From: Max Hirst [REDACTED]
Sent: 04 September 2026 11:24
To: Hebe Smith <Hebe.Smith@arun.gov.uk>
Subject: BR/134/26/PL Town Council Representation

OBJECTION

Overconcentration of Houses in Multiple Occupation and Erosion of Family Housing (Arun Local Plan Policy H SP4(a); National Planning Policy Framework Policy DP3)

Drawing No: 260107 - 3.01 Rev: B

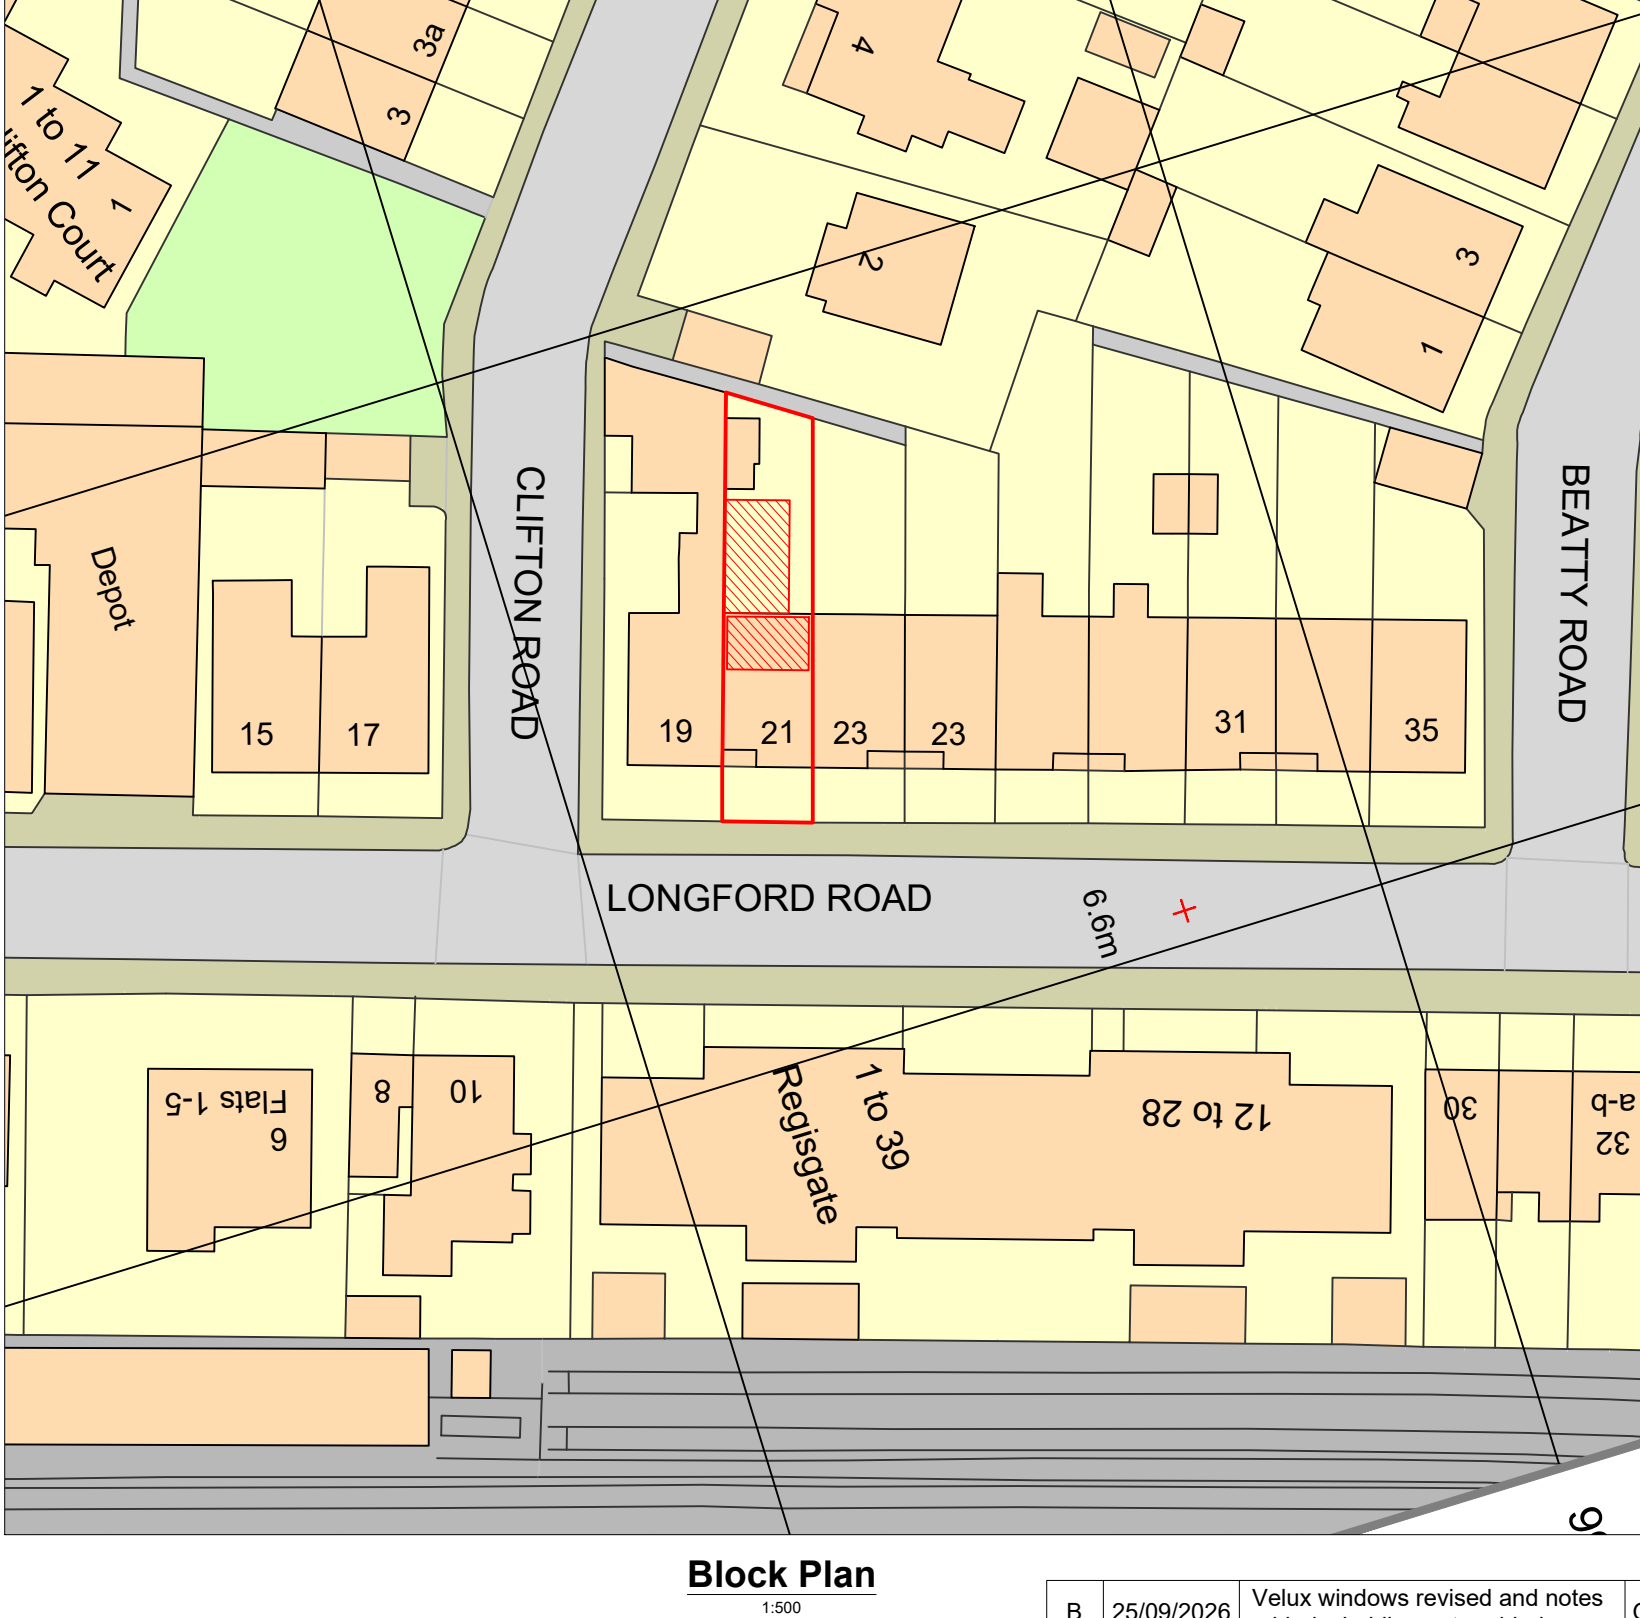
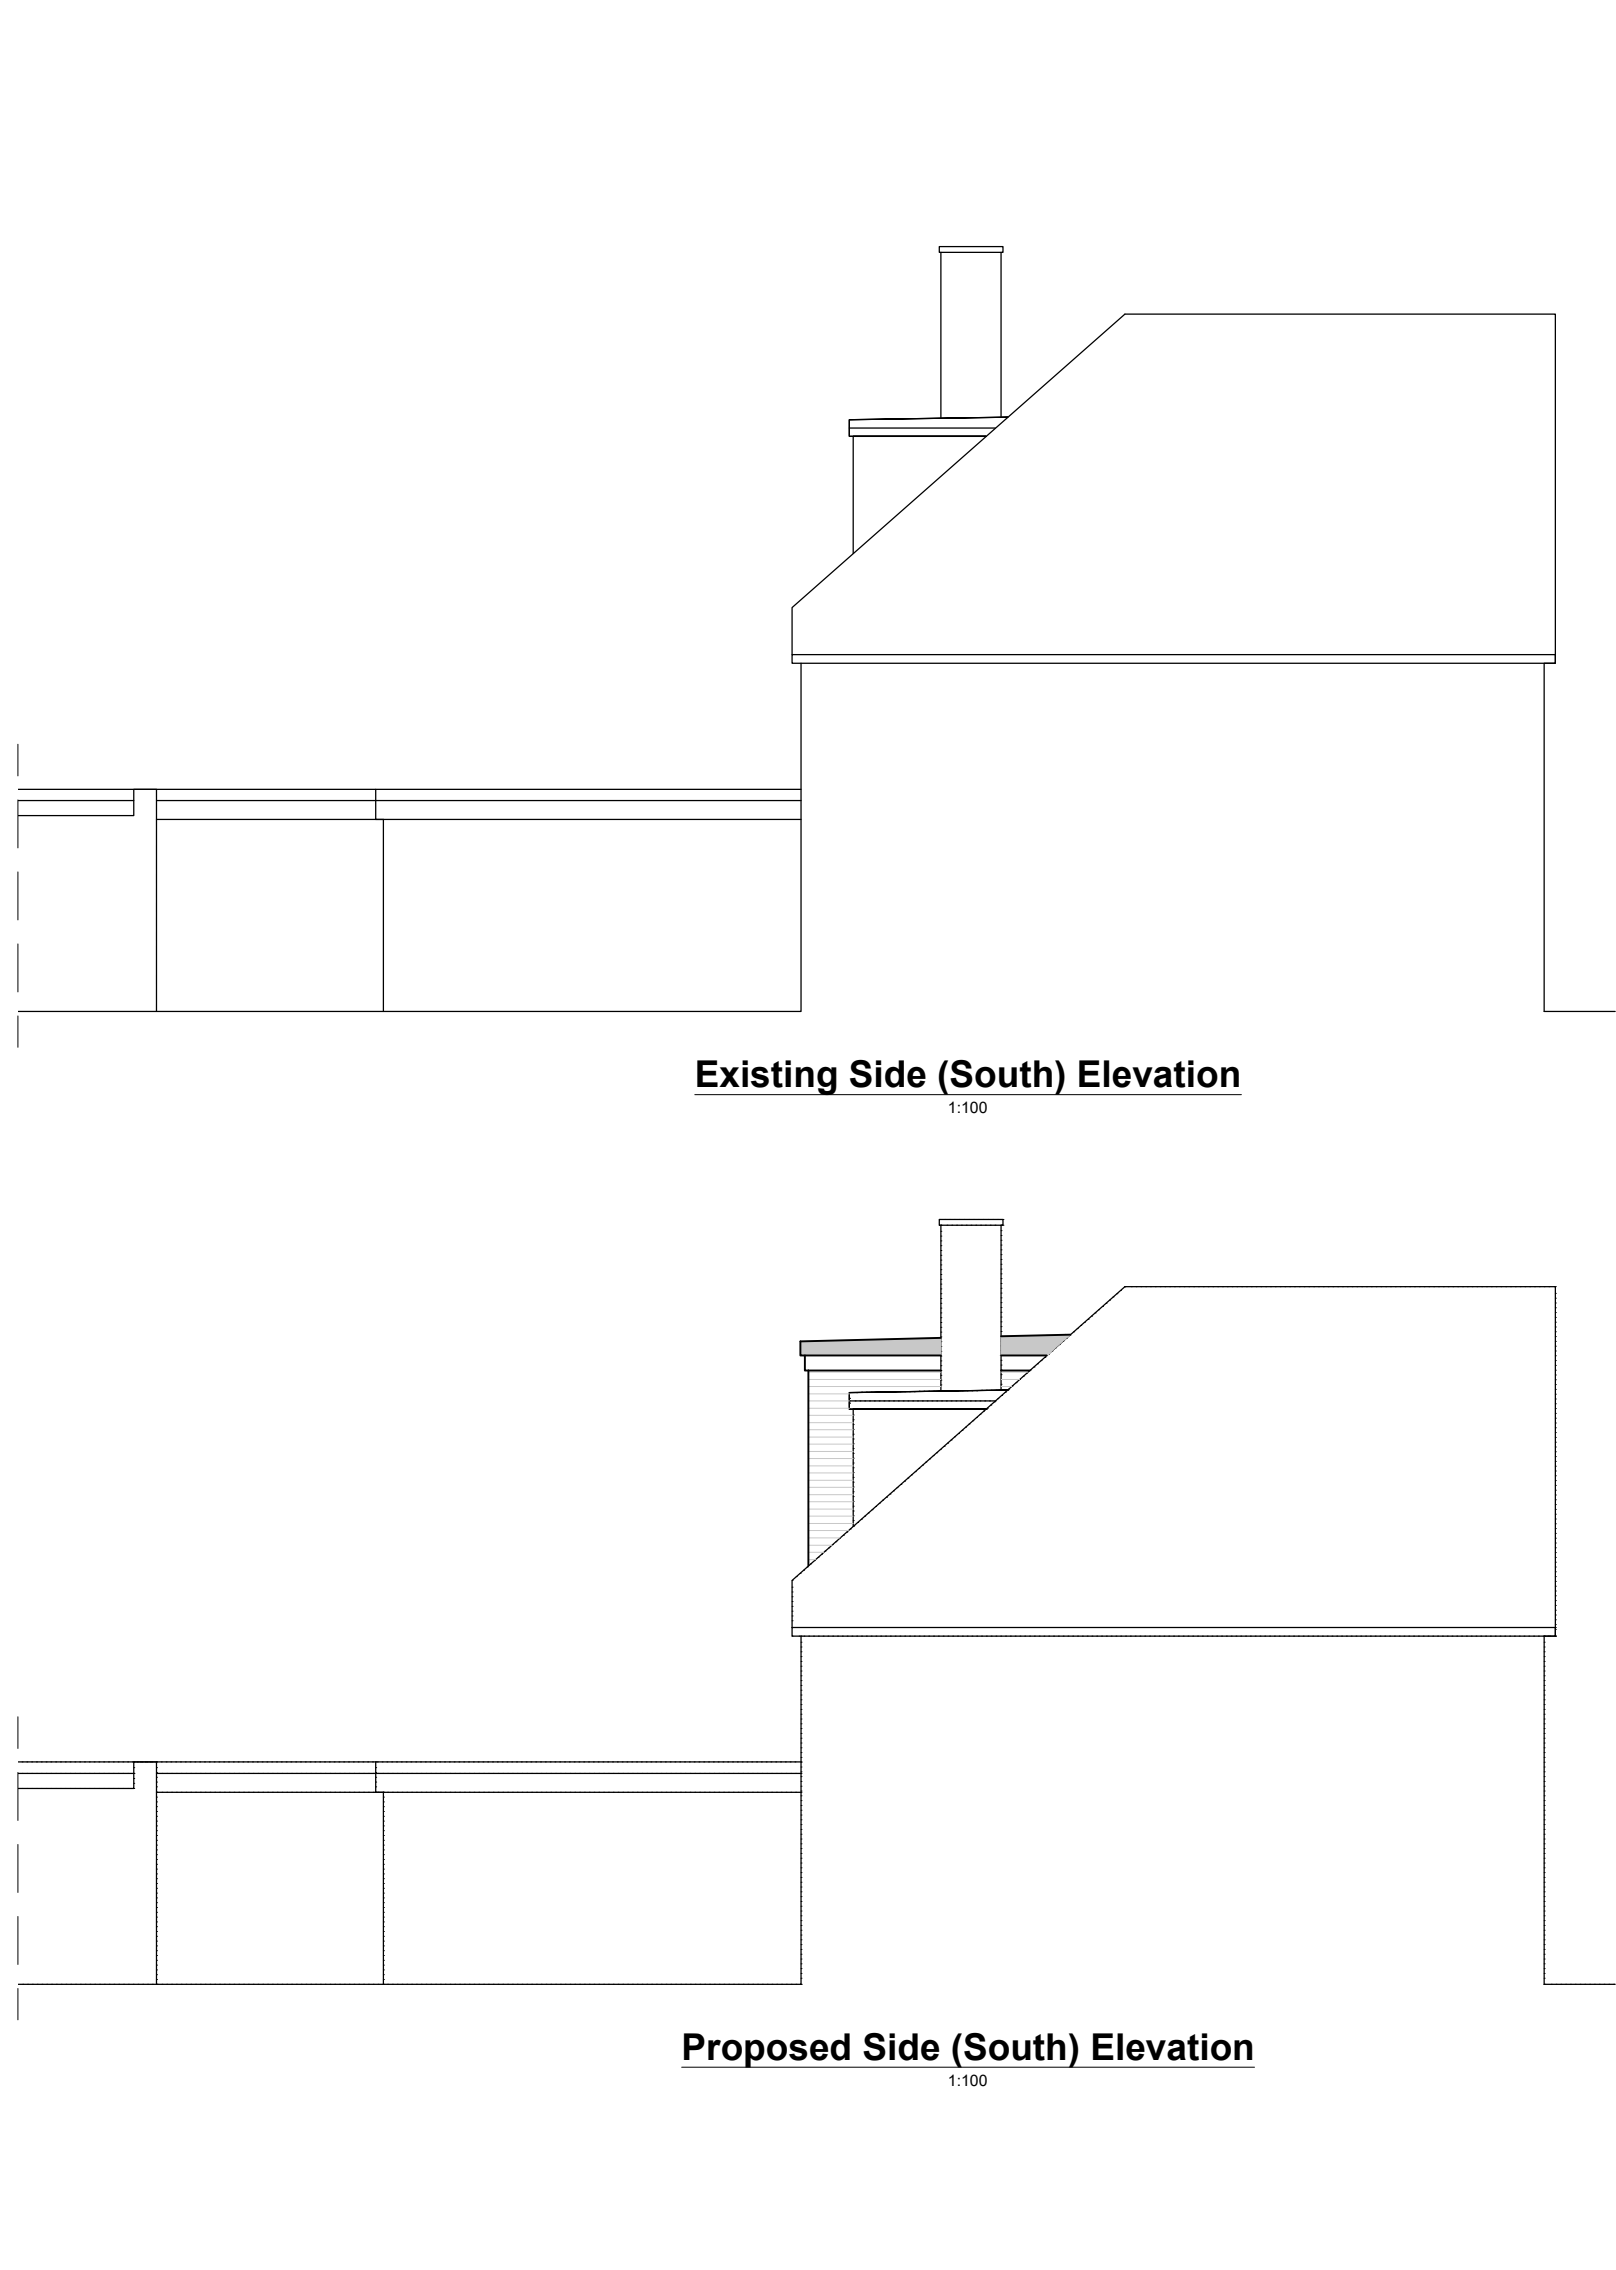
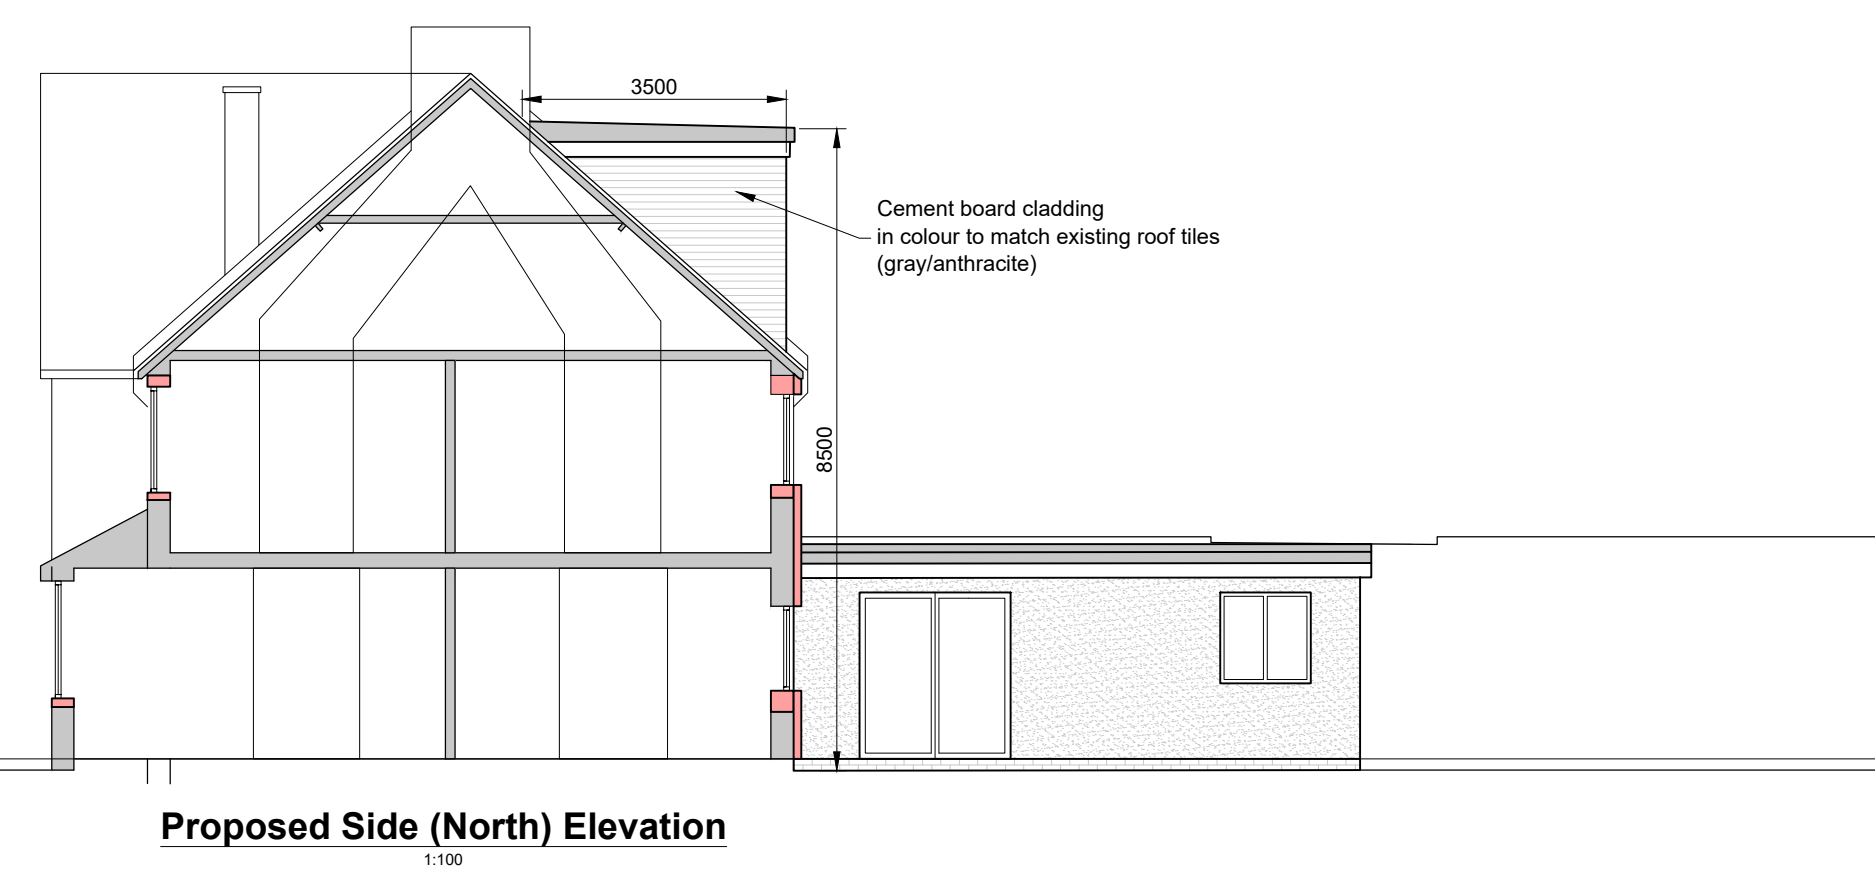
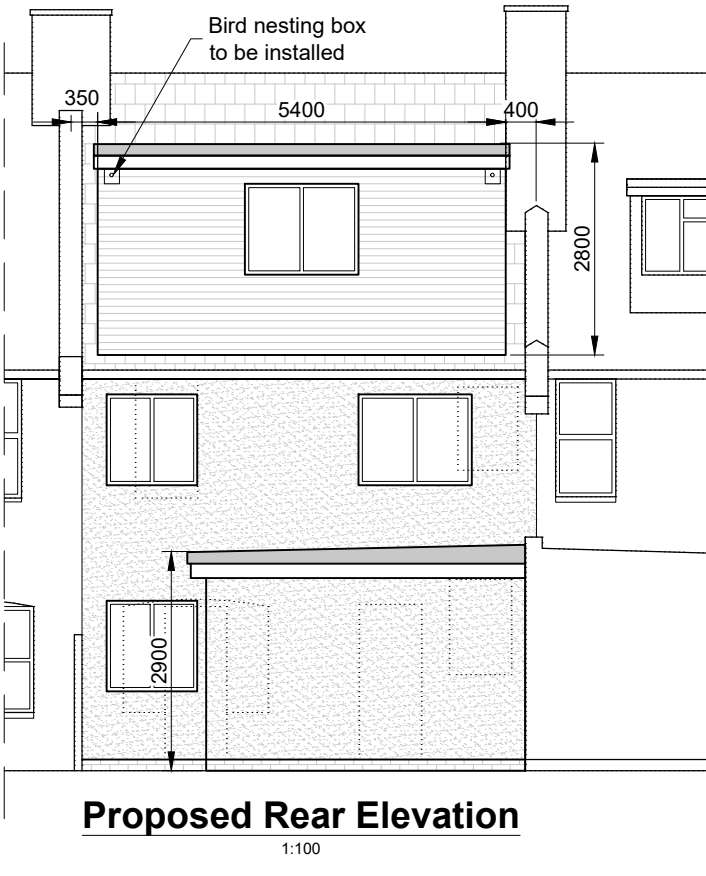
The proposed eight-bedroom HMO would provide no off-street car parking.

Members consider that the conversion of this modest mid-terraced property into an eight-bedroom HMO, facilitated by a 7.5-metre rear extension and substantial rear dormer, represents an excessive intensity of development for the constrained plot.

The applicant acknowledges that the claimed 53 square metres of external amenity space and garden depth of 7.3 metres fall below the Council's respective targets of 70 square metres and 10.5 metres. Moreover, a material proportion of the claimed area comprises the narrow 1.61-metre-wide passage alongside the rear extension rather than readily usable communal garden space.

The remaining rear garden must also accommodate covered storage for eight bicycles, associated access, communal seating and planting. Members therefore consider that the amount of genuinely usable and unconstrained outdoor amenity space would be appreciably less than the headline figure stated by the applicant and would be inadequate for eight independent occupiers.
